Ref: A/131/15/RES – Land South of A259 and West of Mill Lane, Rustington; Parish of Angmering

We note the comments made by ADC Parks and Landscapes on 22 October 2015, and Angmering District Council on 23rd October 2015 and have consequently given our Landscaping proposals further consideration.

scheme: Mill Lane Site
Rustington
client: Store Property
drawing: Landscape Proposals
date: July '15
scale: 1:200@A1
drawing no: STORE18832 17J
drawn: DKM checked: AE

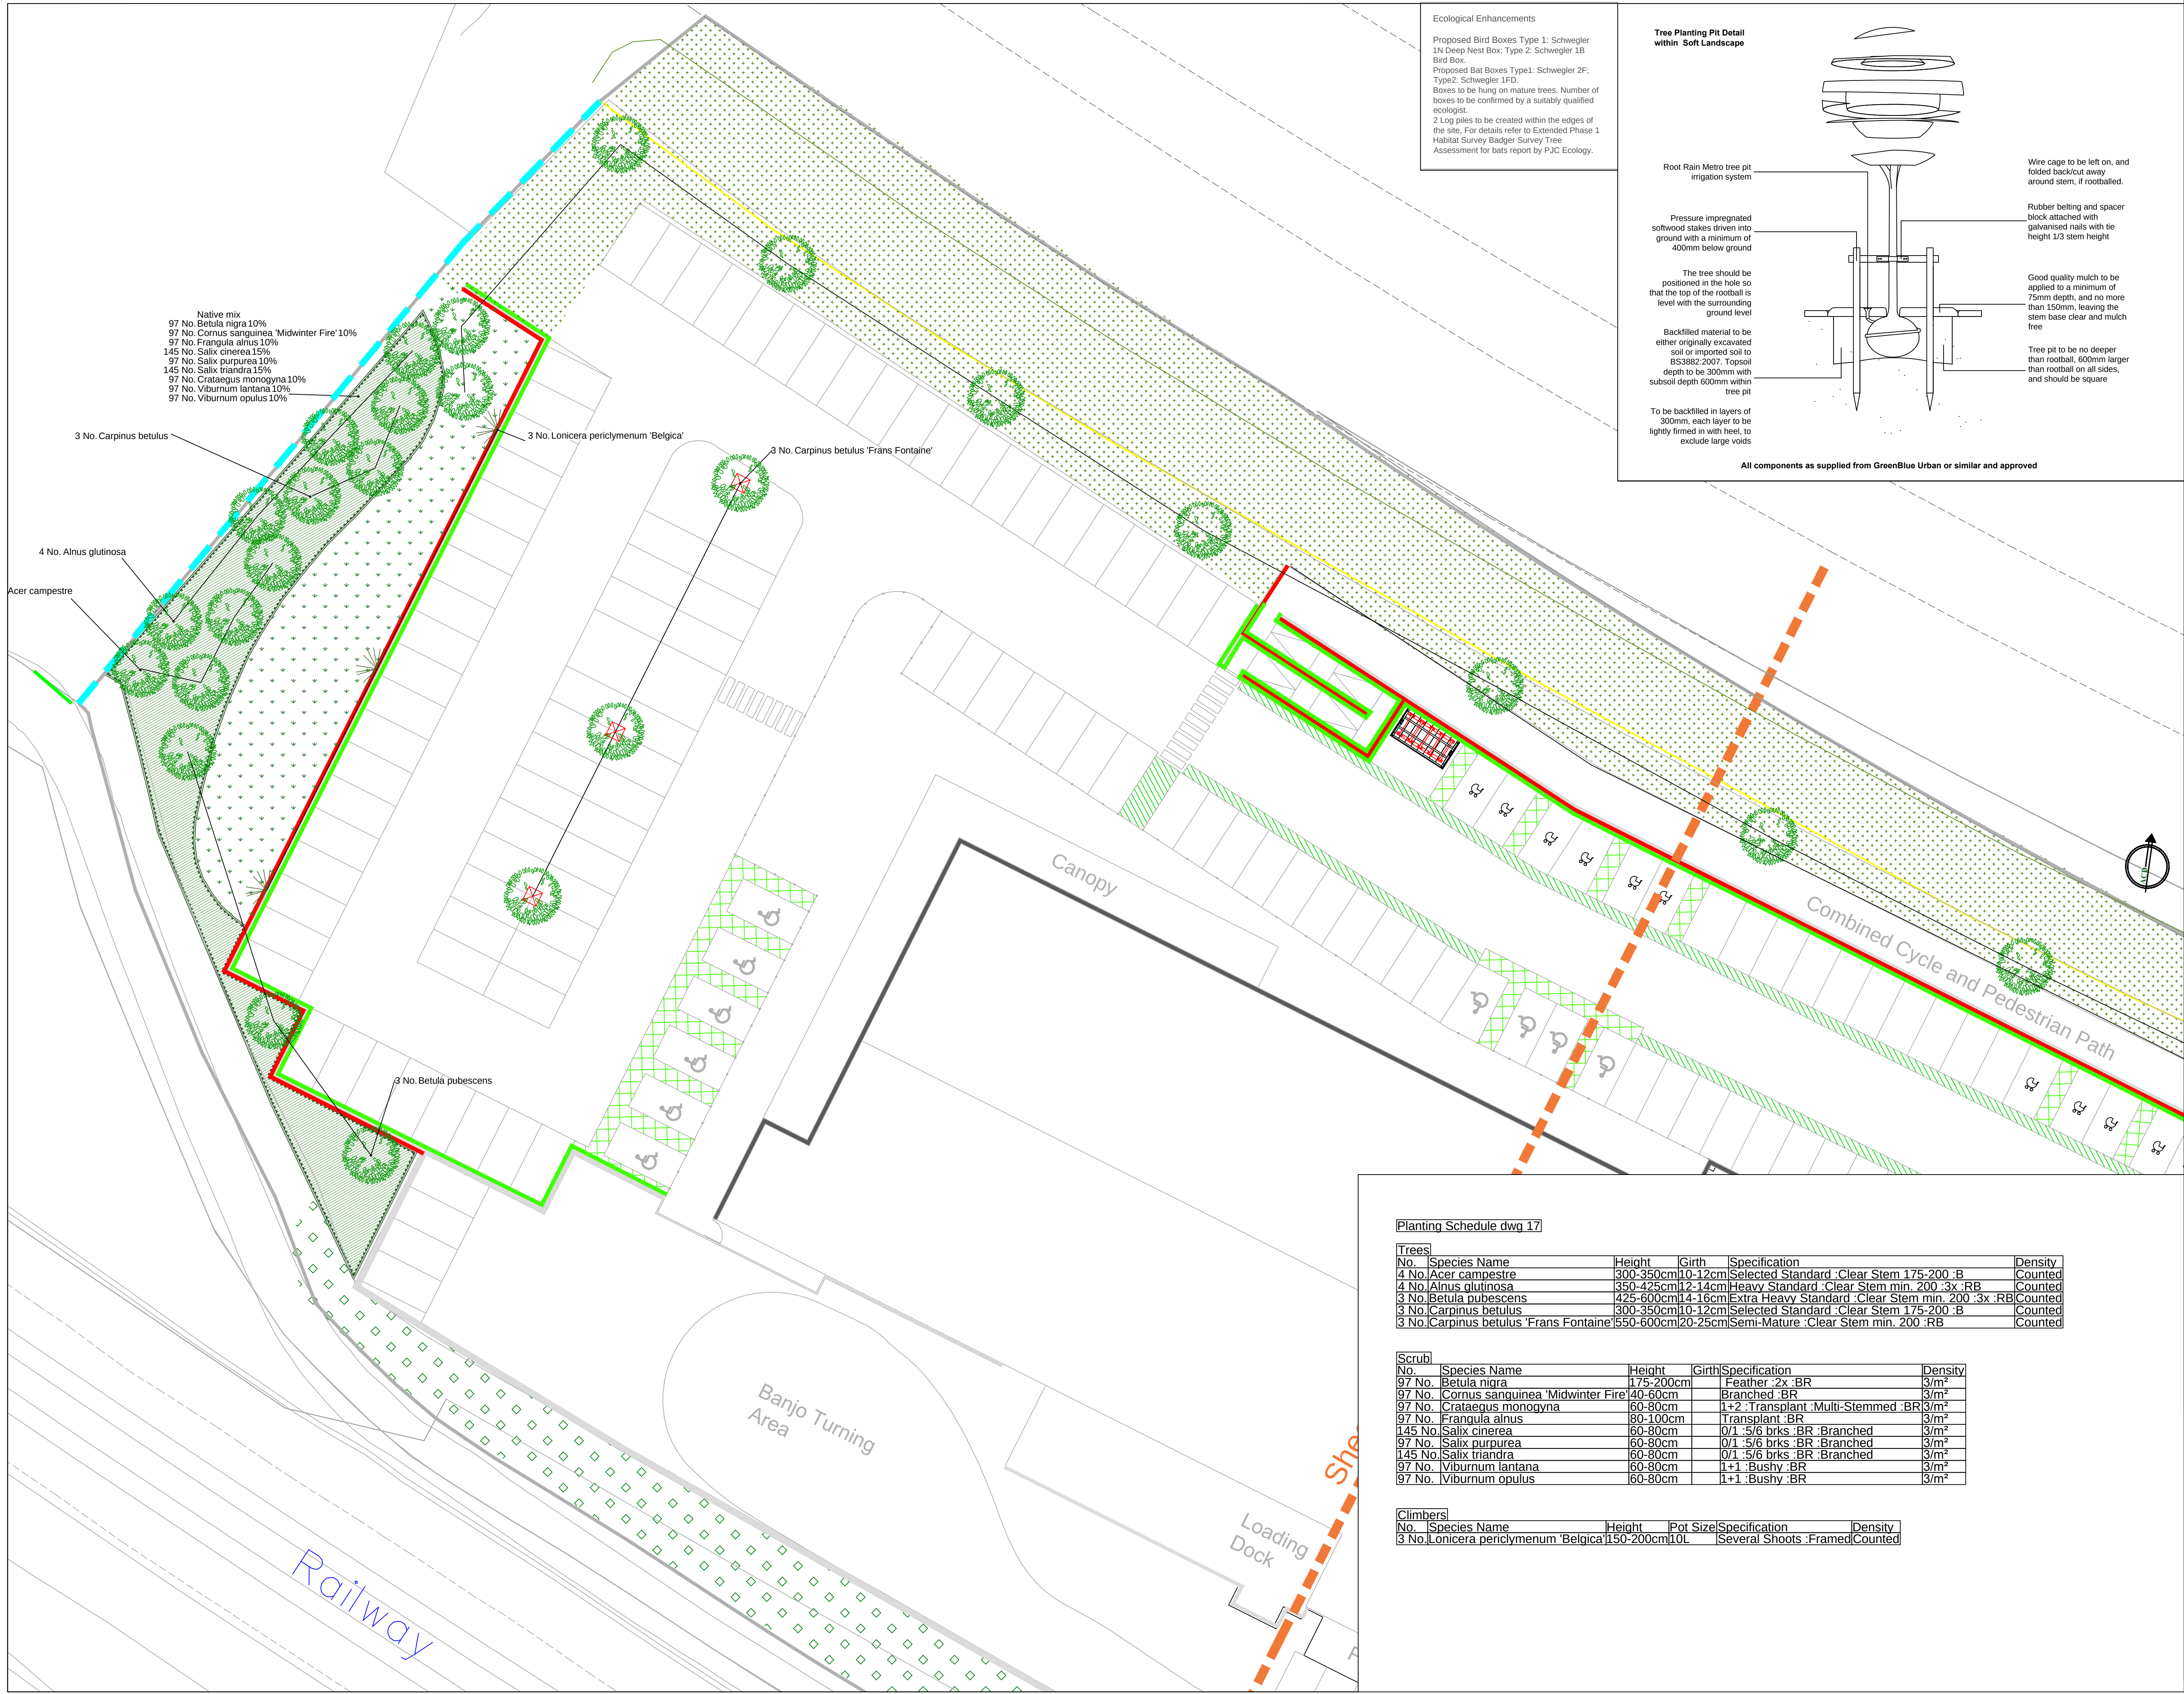
Landscaping opportunities to the rear of the site are constrained by the proximity to the railway. Network Rail require us to maintain a 3m casting way zone which must be clear of trees in order to protect Network Rail infrastructure so we will not be able to provide the trees shown on the indicative 2013 Outline proposal drawings. Our current scheme therefore proposes that this area is planted with wildflower mix which will create a biodiverse and attractive rear boundary.

We note that ADC are also concerned about the number of trees currently proposed overall and as such as well as the additional trees to the northern boundary, we have now significantly increased the number of proposed trees within the western planting area too. These will create an attractive and pleasant environment and additional wildlife habitat. The revised proposal will provide one new tree for each valued tree lost. Native species have been chosen for their biodiversity and wildlife value.
